Permitting and Inspections Department  
Michael A. Russell, MS, Director

**CBL: 192 H023001**  
**Located at: 84 MACHIGONNE ST**

**Inspection Violations**

#2 Right Side Exterior Elevation

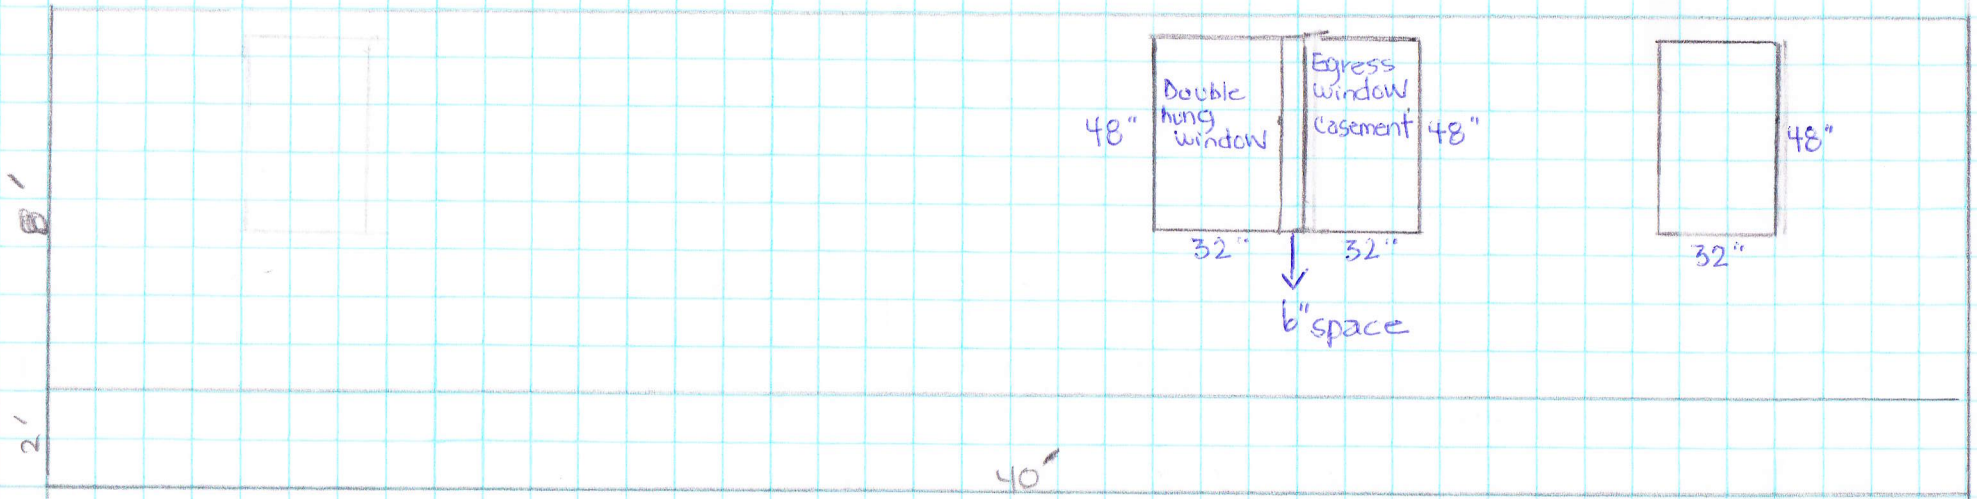
**Violation:** ESCAPE WINDOWS; Escape Windows - One and Two-Family Dwellings: Escape windows shall be a free and clear outside window or door operable from the inside without the use of tools, keys, or special effort. Windows shall be within 20 feet of the finished ground level or accessible by rescue apparatus (if approved), or opening onto an exterior balcony and when below ground level shall be provided with an accessible, free and clear, window well.  
NFPA 101 (2009) 24.2.2.3.3

**Notes:** Bedrooms. (plan of action in 30 days)

**Notes:** basement bedroom lack viable secondary egress. Bulkhead poses serious risk due to potential complications from snow and ice and may not work during an emergency. (plan of action in 30 days)
